Application Ref:	3/2020/1091	 Ribble Valley Borough Council www.ribblevalley.gov.uk	
Date Inspected:	26/01/2021		
Officer:	LE		
DELEGATED ITEM FILE REPORT:		Decision	REFUSE

Development Description:	Proposed redevelopment of site for 30 no. holiday chalets, conversion of existing holiday house and adjacent barn to a 20 person holiday let. Extension of existing cafe, construction of reception building with managers flat, alteration to existing garden centre to form a farm shop and plant display area. Creation of car parking, landscaping and associated works.
Site Address/Location:	Coars Farm Garden Centre, Settle Road, Bolton By Bowland, BD23 4SN

PROPOSED PLANS AND ELEVATIONS OF LODGES

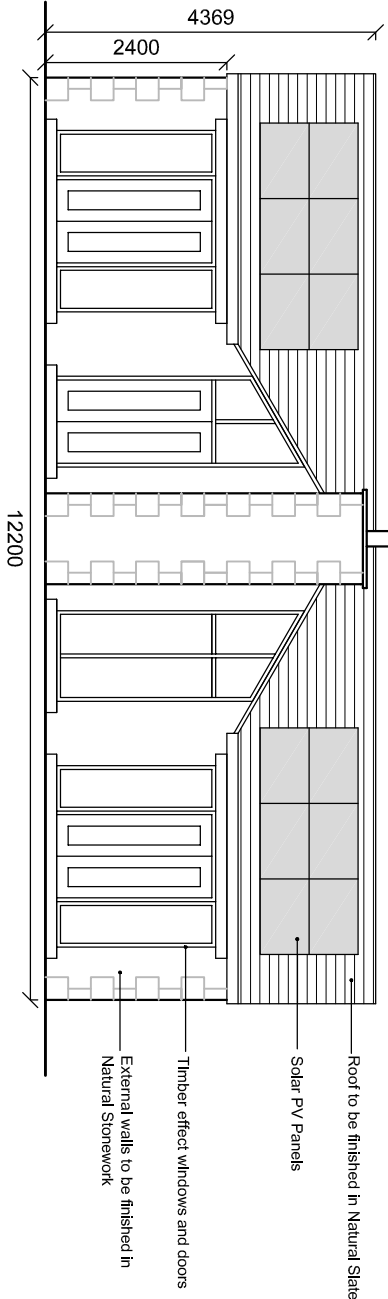
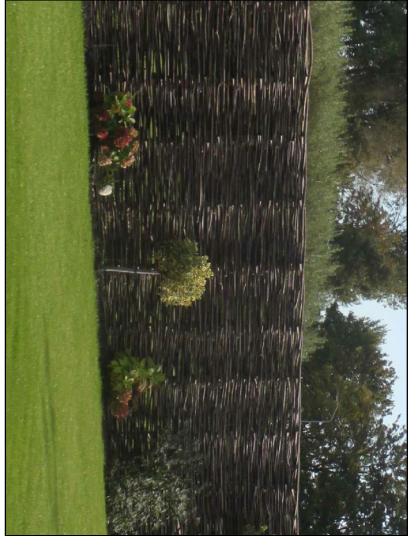
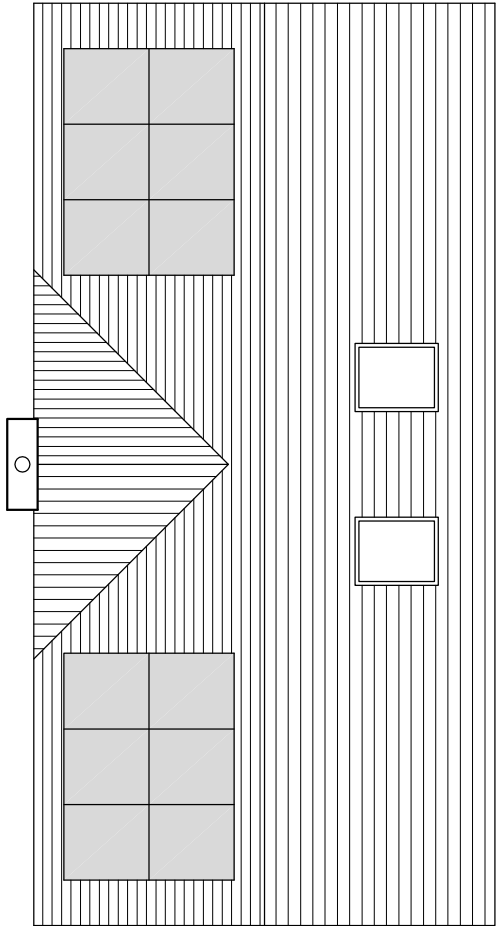
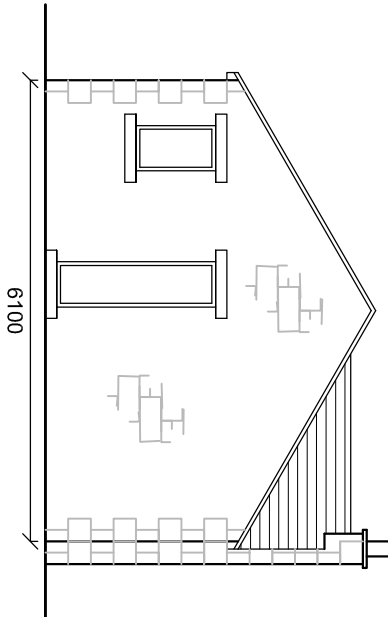
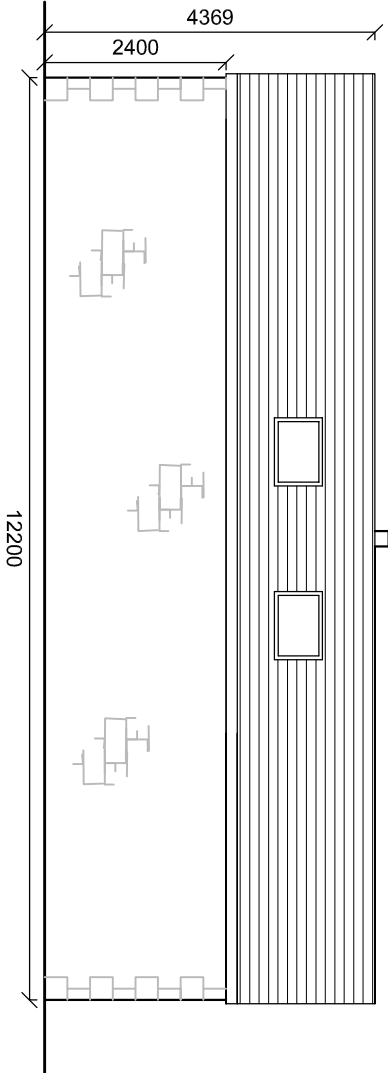
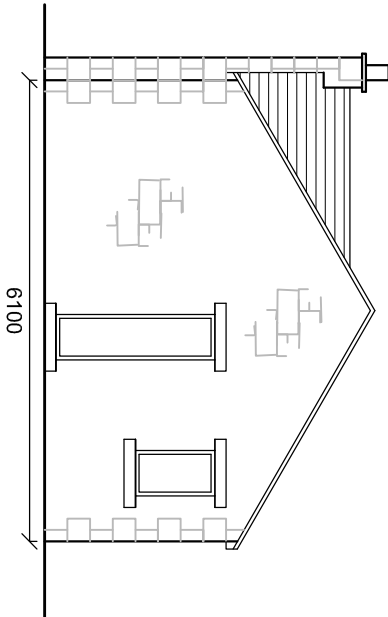
The proposed lodges are to be constructed in stone and timber with slate roofs partially covered in solar panels in a semi-formal layout with expanses of hardstanding providing each with a vehicular access point. Each lodge also appears to have a covered hot tub area to the front. It has an appearance akin to a small housing development. In this respect it cannot be reasonably argued that the design, external appearance nor materiality of the structures aligns with the criterion of Key Statement EN2 in respect of being 'in keeping with the character of the landscape, reflecting local distinctiveness, vernacular style, scale, style, features and building materials'. Nor does it reflect the particular landscape character of "Rolling Upland Farmland" described above. The discordant appearance of the proposed development is exacerbated by the expanses of hardstanding, parking and encroachment into a previously undeveloped area of the site alongside the road. Lighting required to serve a development of such a scale could cause excessive light pollution into an area that is currently largely devoid of development which would impact on dark skies

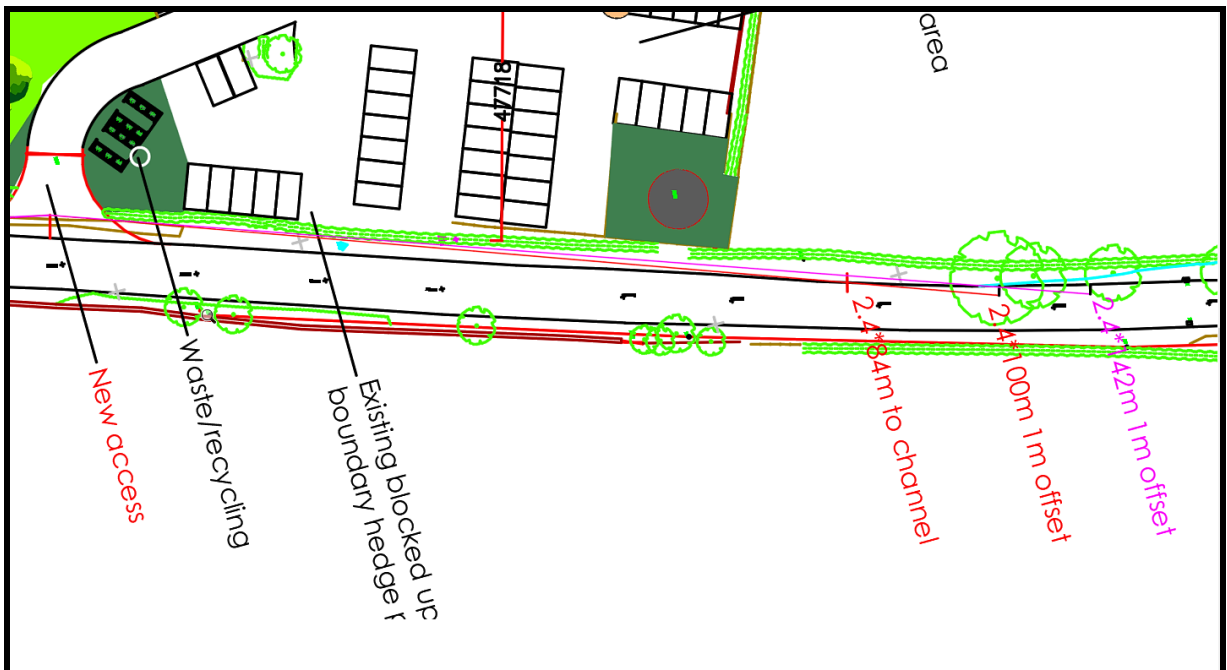
- The parking provision seems excessive
- 6 metres is required to the rear of parking spaces
- Gated access should be set back further than is shown
- Visibility splays should be maximised to account for higher vehicle speeds
- A swept path analysis for emergency vehicles is required
- Better links to public rights of way should be explored
- Land drainage consent is required from LCC
